# CITY OF ALBUQUERQUE

July 11, 2018

**RE: Utility Trailer Sales  
8201 Daytona Rd NW  
Grading Plan Stamp Date: 6/27/18  
Drainage Report Stamp Date: 5/14/18  
Hydrology File: K09D026B**

ENGINEER'S SEAL VINCENT P. CARRICA P.E. #16212	UTILITY TRAILER SALES ALBUQUERQUE NM GRADING AND DRAINAGE PLAN	DRAWN BY LA
	DATE 4/20/2018 2017041-GRADING	SHEET # C2 JOB # 2017041

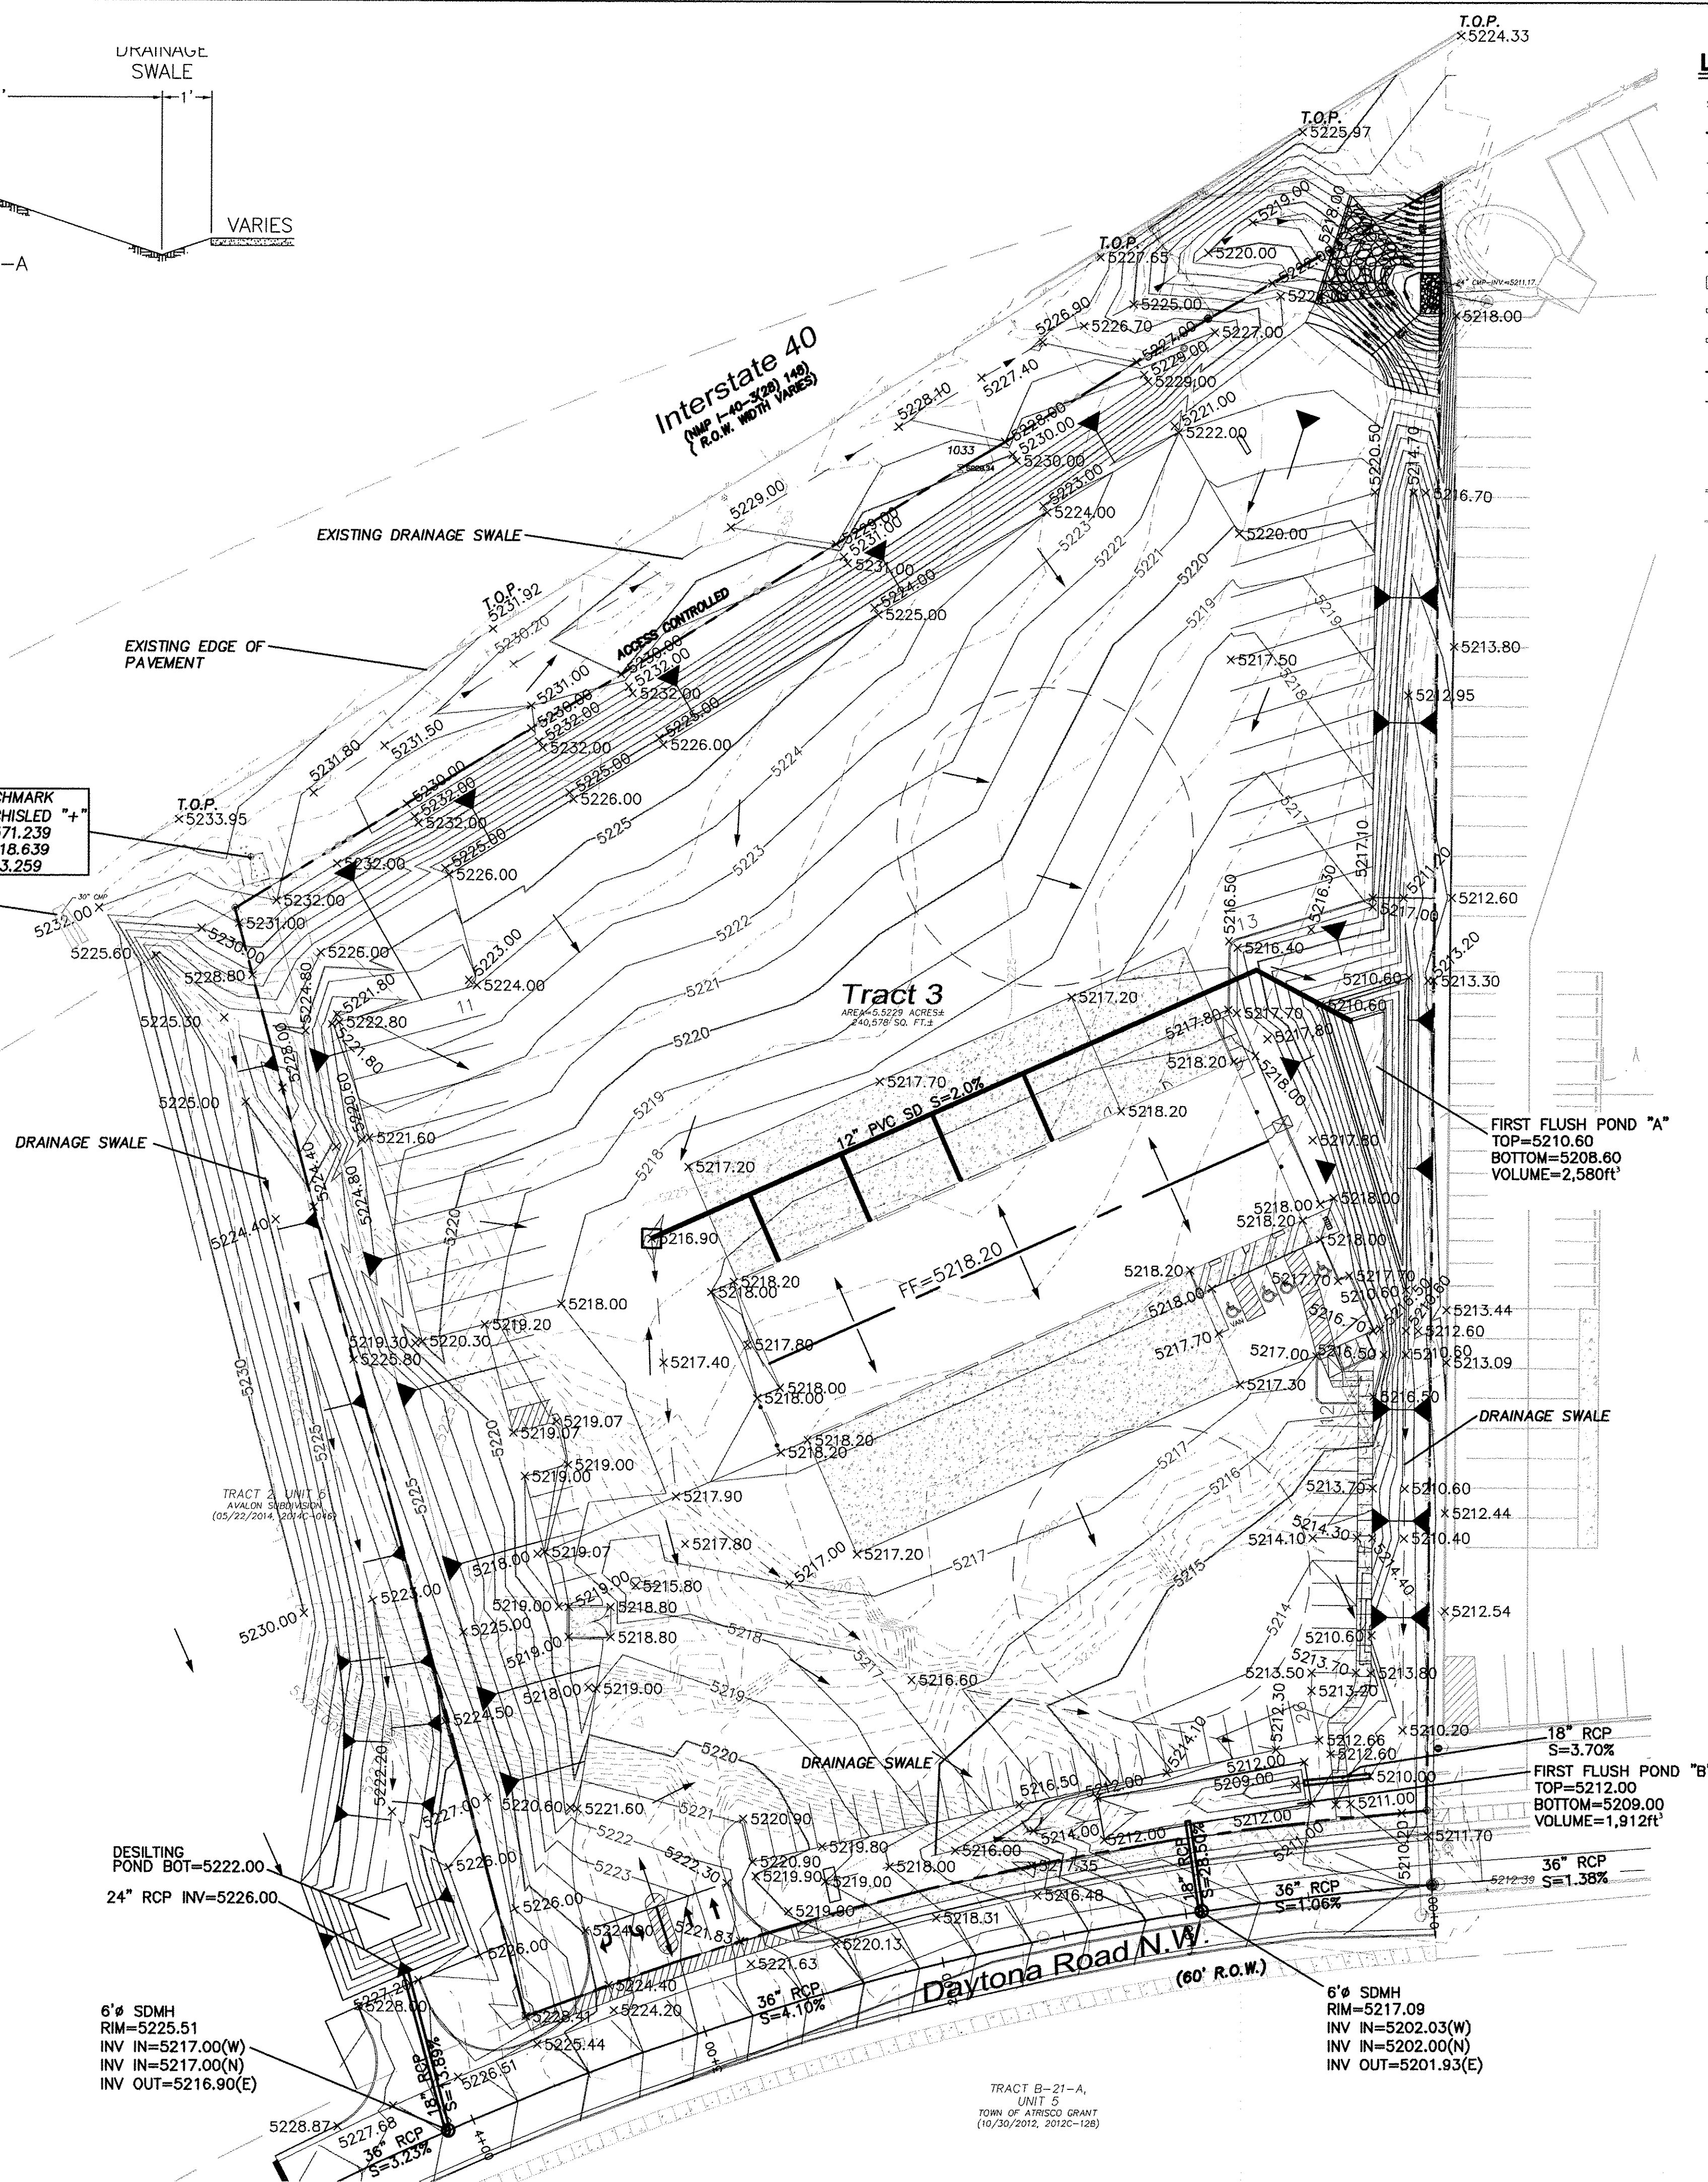
1. The grading in the SE corner of the site is still unclear. Please provide a detail view of the grades in this corner showing the grades on both sides of the property line and ROW line. Many of the proposed spot elevations overlap making it difficult to discern proposed grades. What is the flow depth in the drainage swale (100-yr)? A short retaining wall or berm may be necessary at the Bruckner property line and the ROW line to force flows west into the culvert. If this is required, provide sections demonstrating no encroachments across the ROW/Property lines.
2. Provide the updated Drainage Report, reflecting the modification made to Pond B and its inlet culvert and outlet pipe/InvertOut.
